Consultee Comments for Planning Application 21/00018/FUL

Application Number: 21/00018/FUL

Address: 1 Dunsil Road Pinxton Nottingham NG16 6RZ

Proposal: Roof extension in height to increase usable floor area

Block Plan

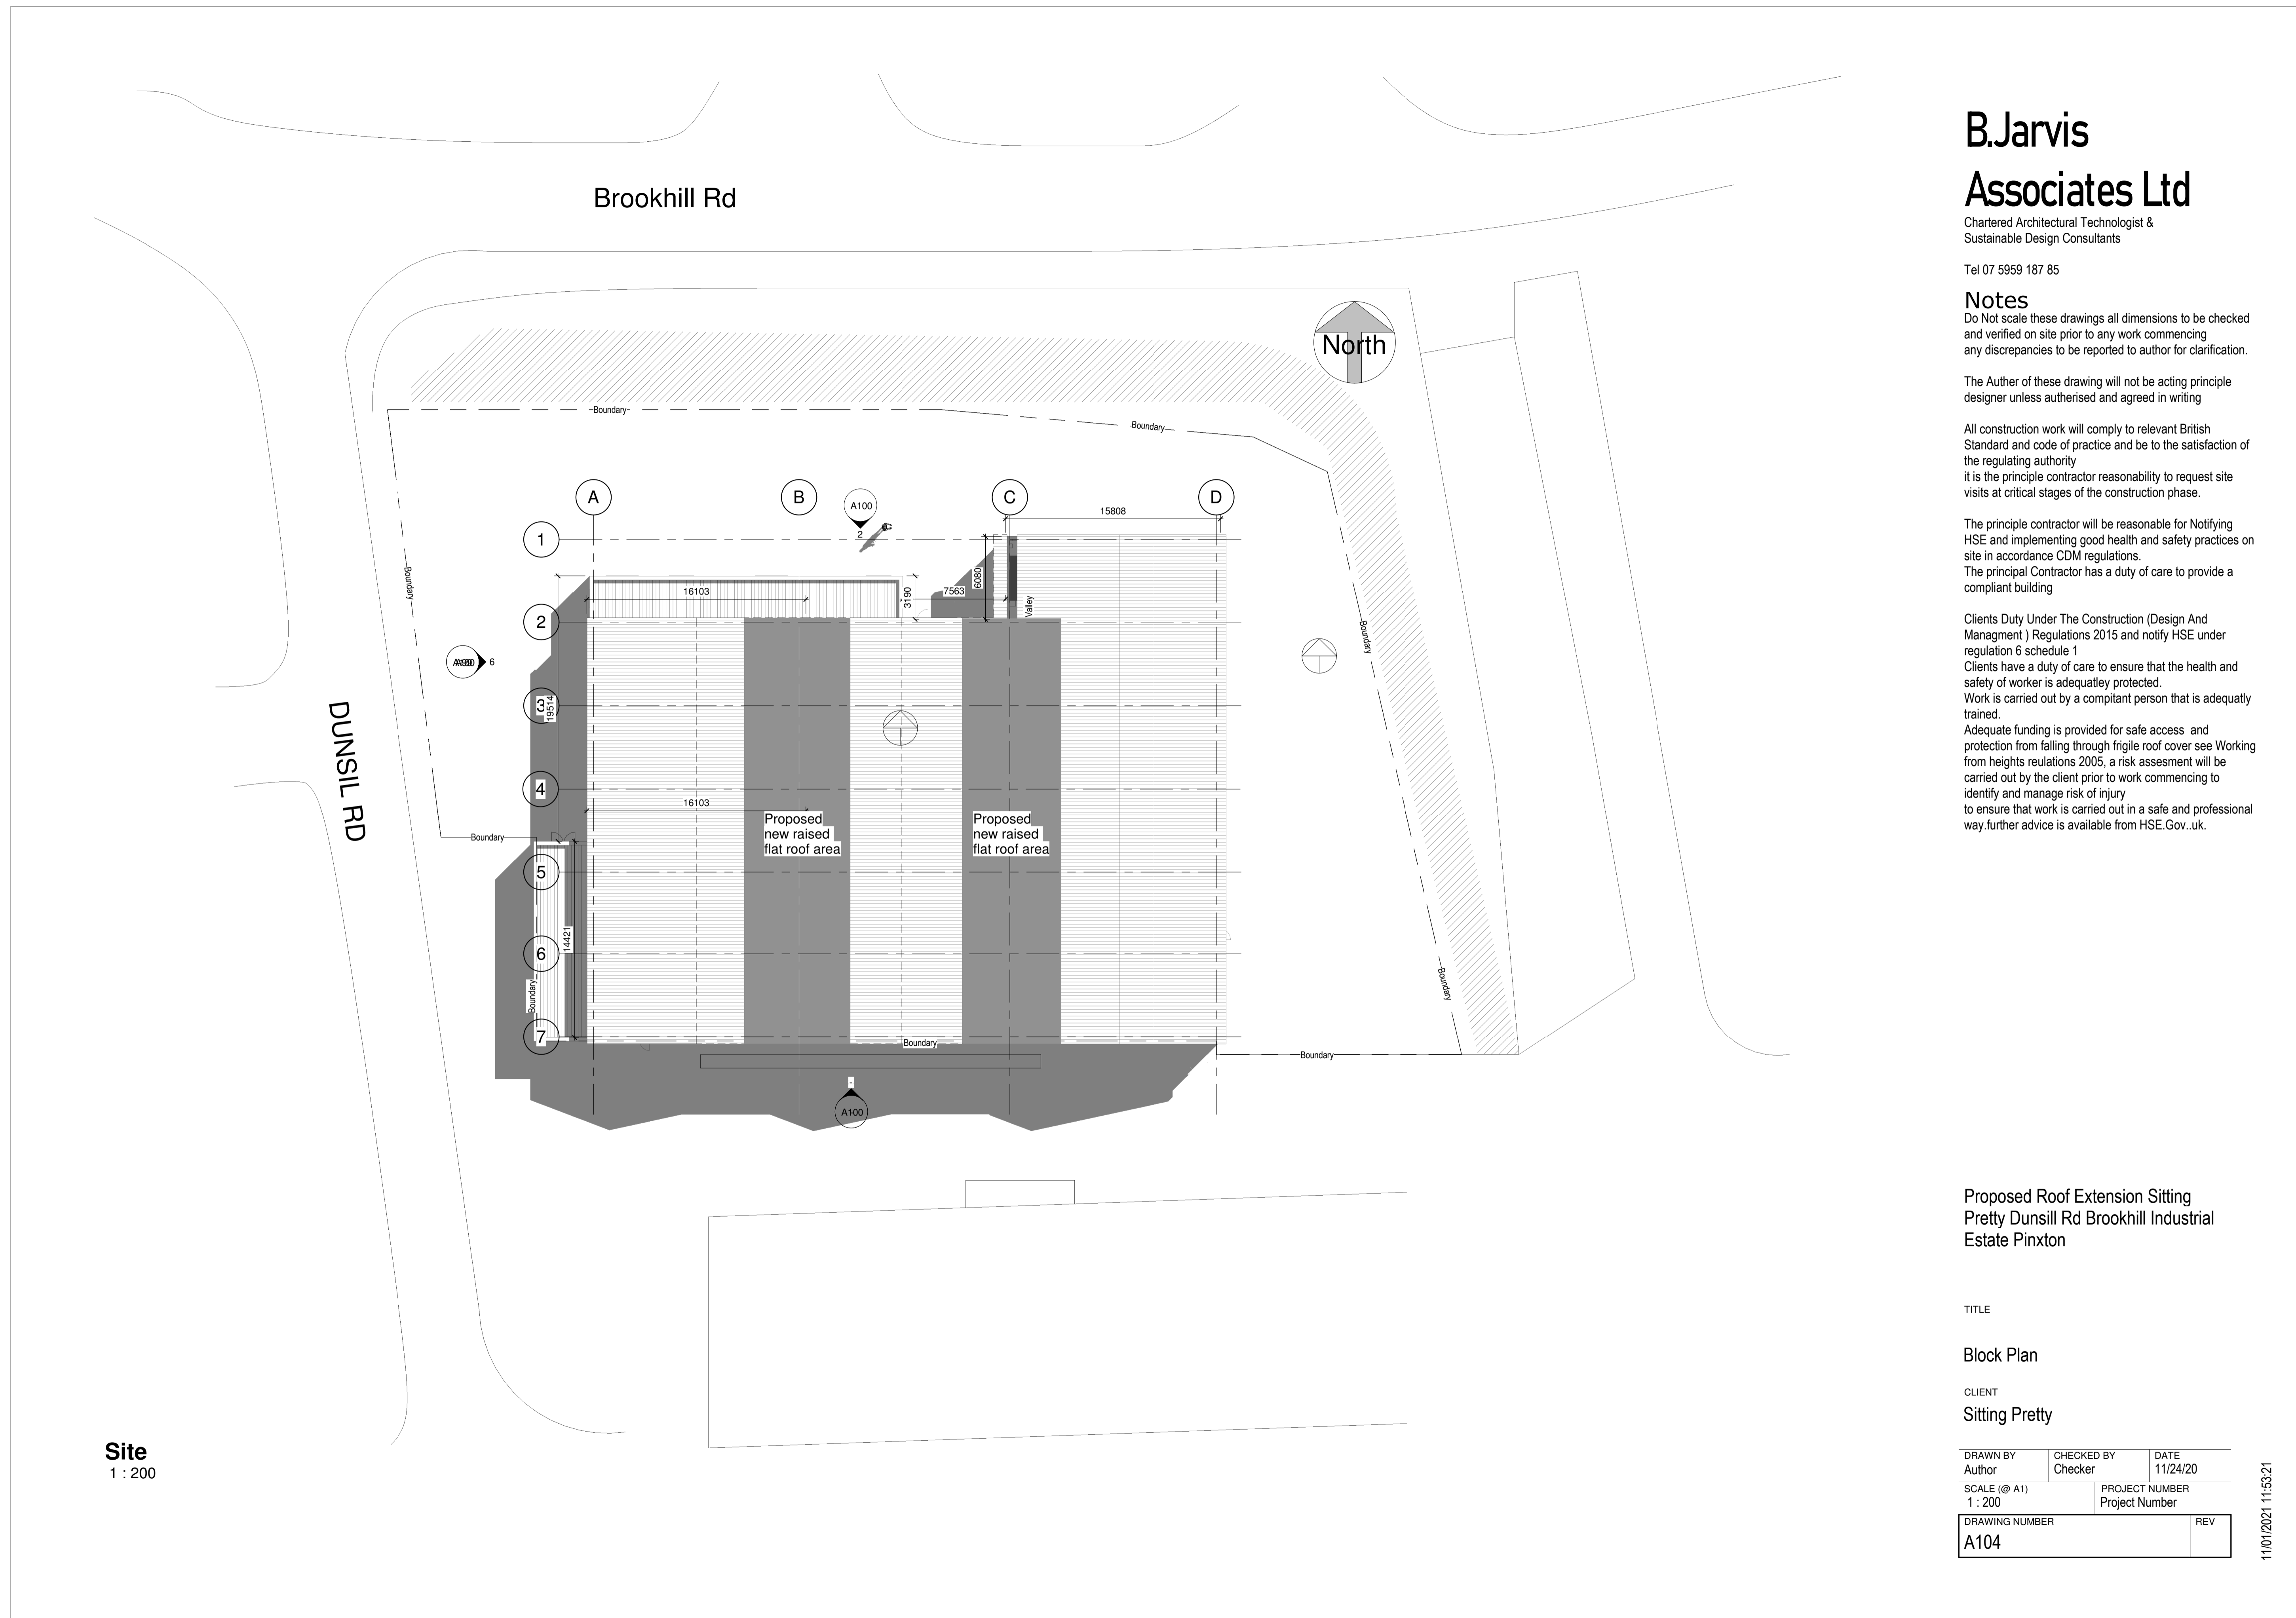
No objection subject to the applicant demonstrating and maintaining adequate off street parking to serve the extended development clear of any obstructions to its designated use and sufficient manoeuvring space to enable the largest vehicles likely to frequently visit the site to enter and exit Dunsil Road in a forward gear
